Laurie Leader - 131 Washington Avenue Plan Review Comments,

Please find my responses to your comments on drawings S-1 and S-2, regarding structural questions that you had.

Rehabilitation of the Main Block and Ell at
131 Washington Avenue
 Jonathan Edwards
 Portland, Maine

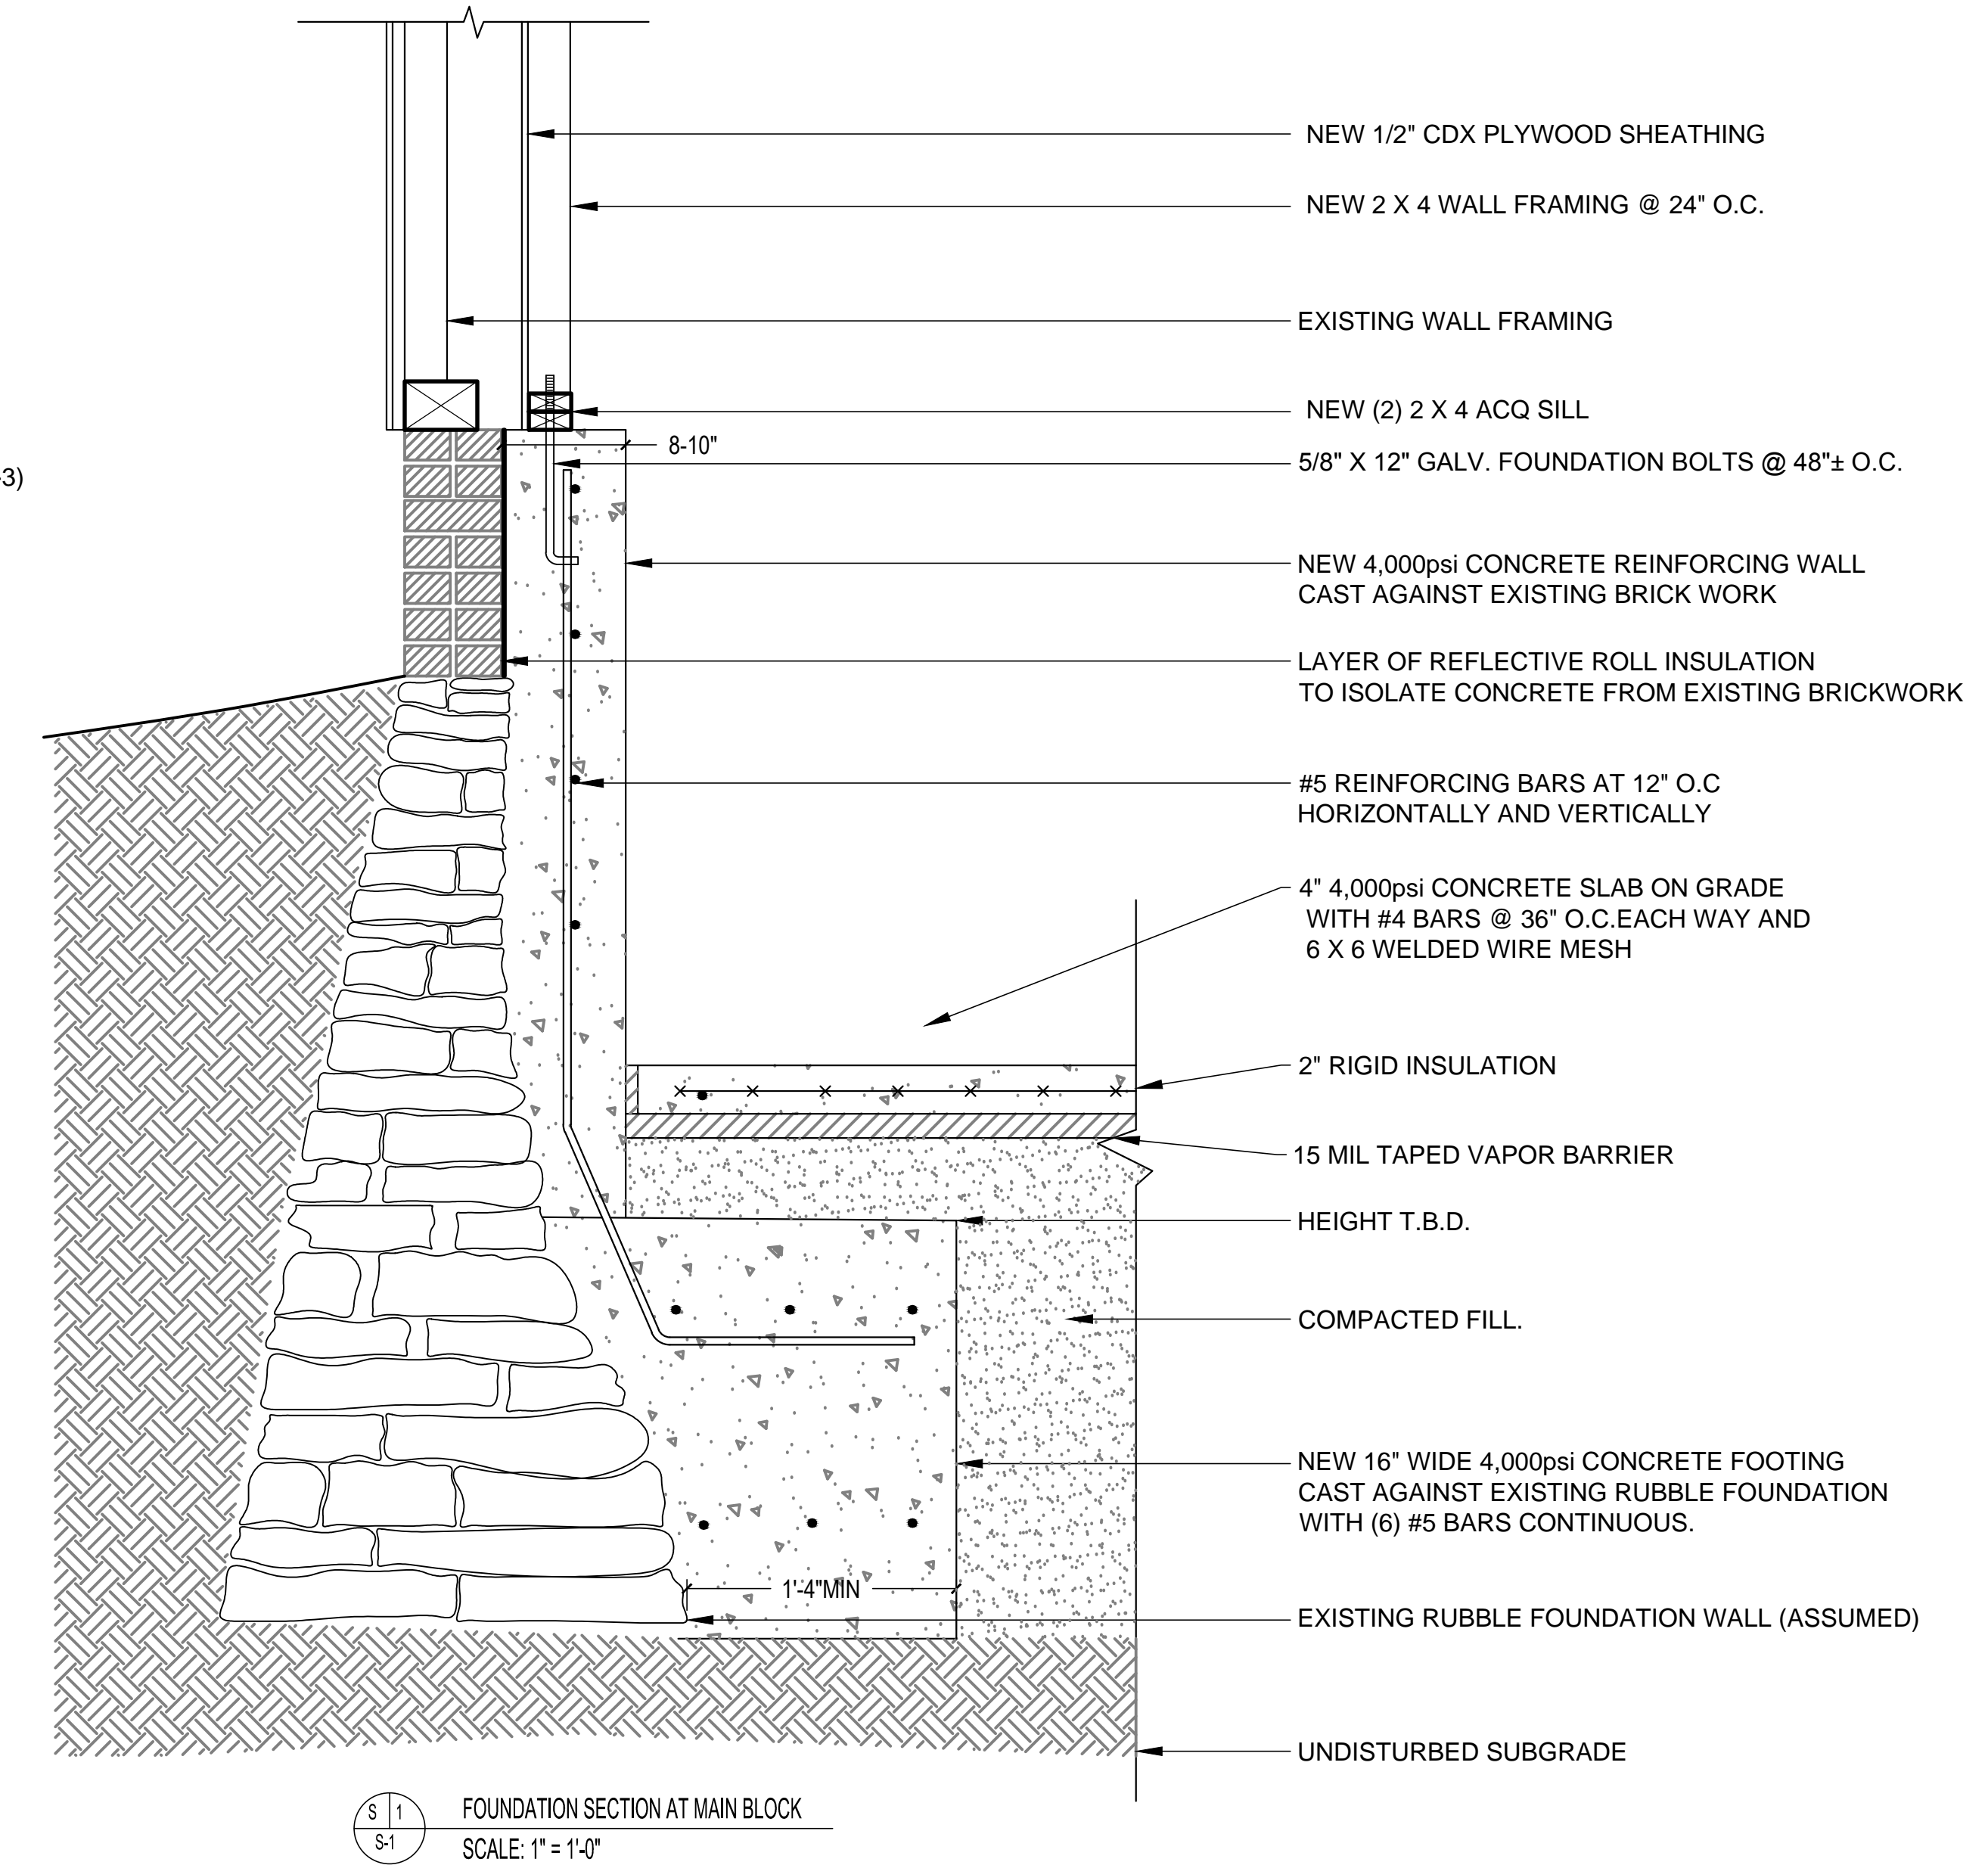
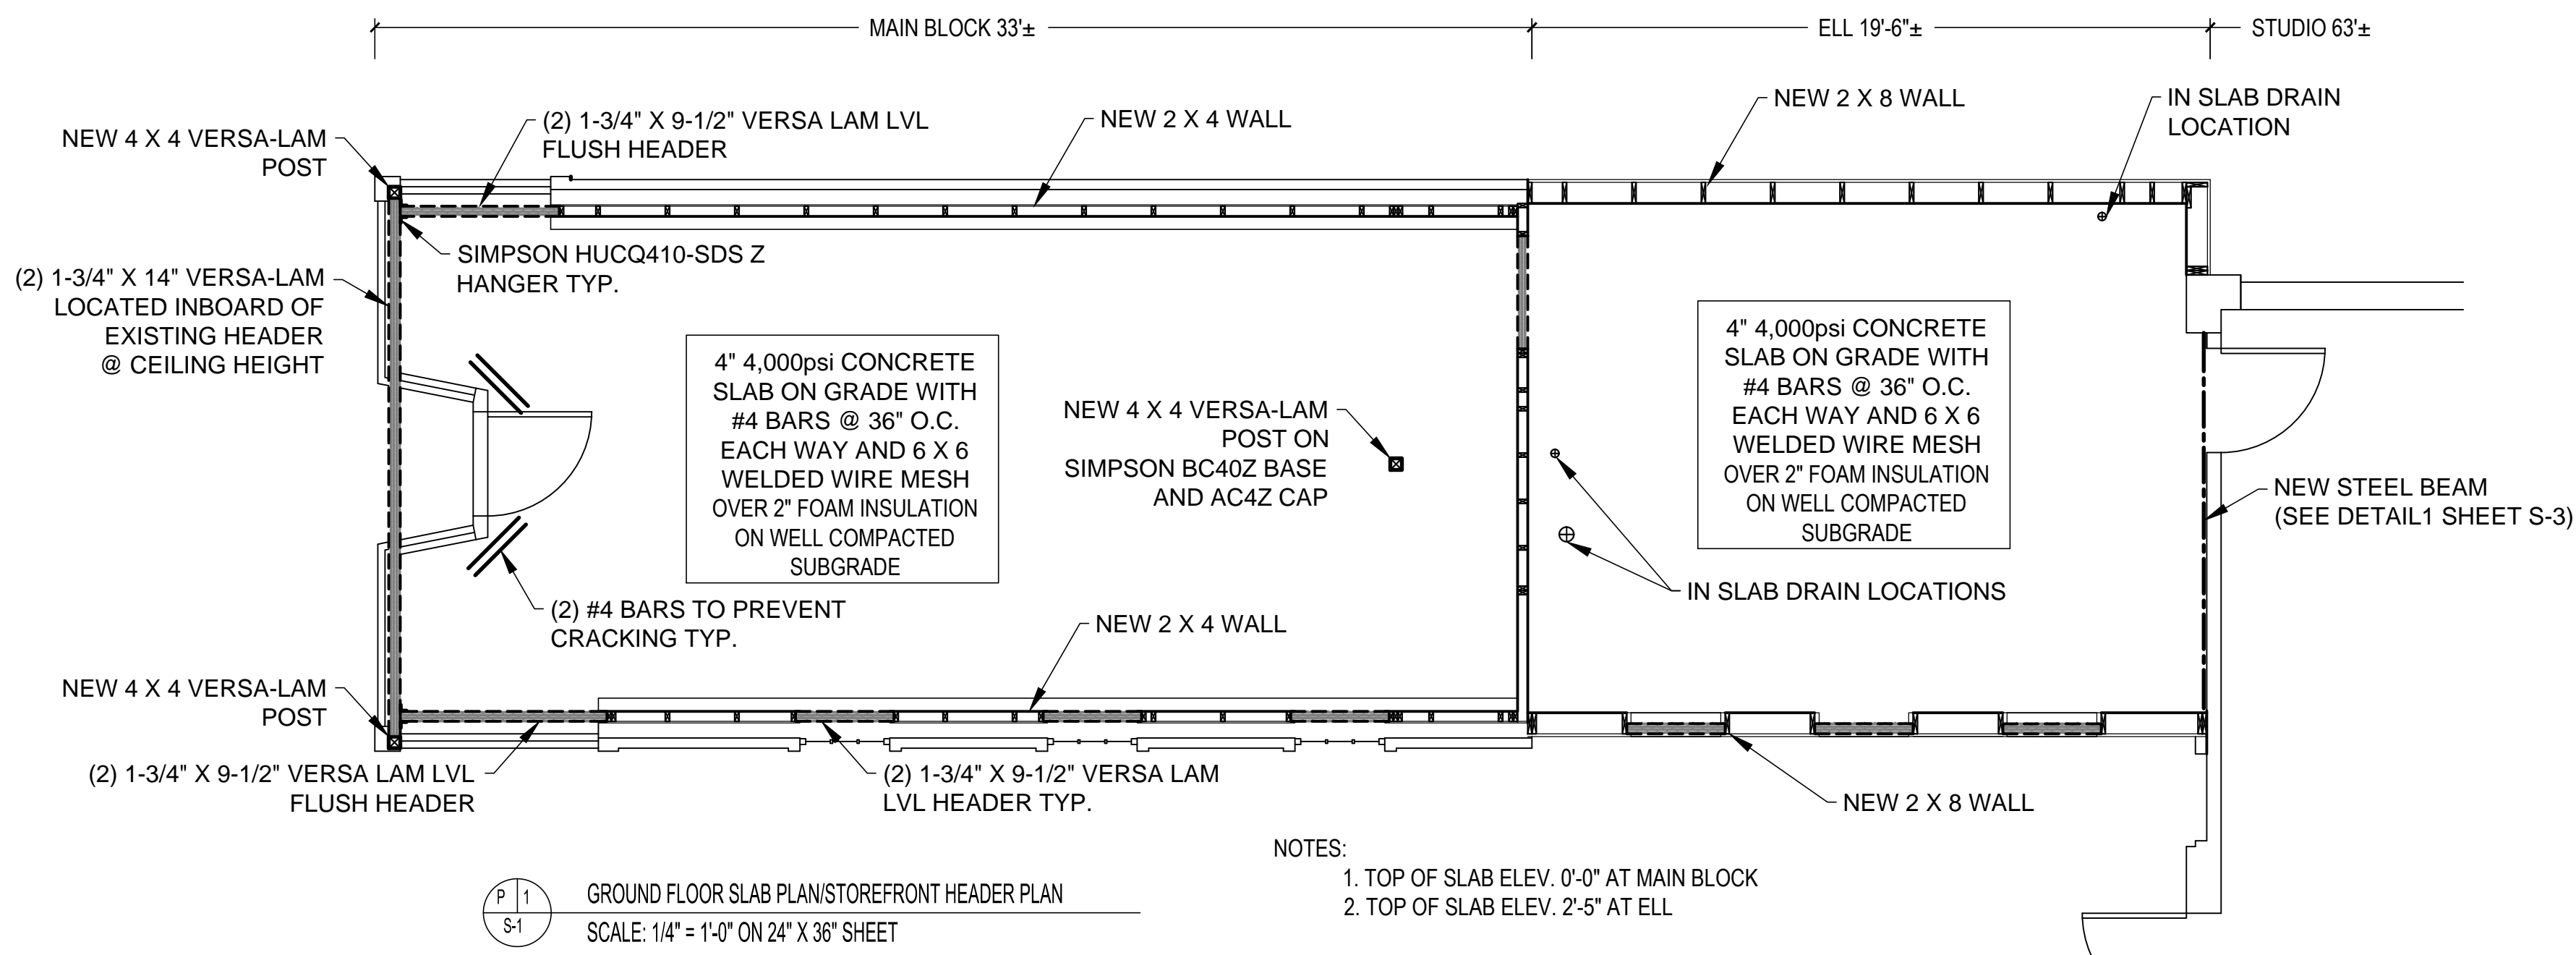
S-1 re: Foundation Work, I will confirm with building Owner Jon Edwards that I will perform appropriate construction observation to sign off on the structural sitework and structural building work as part of construction phase services.
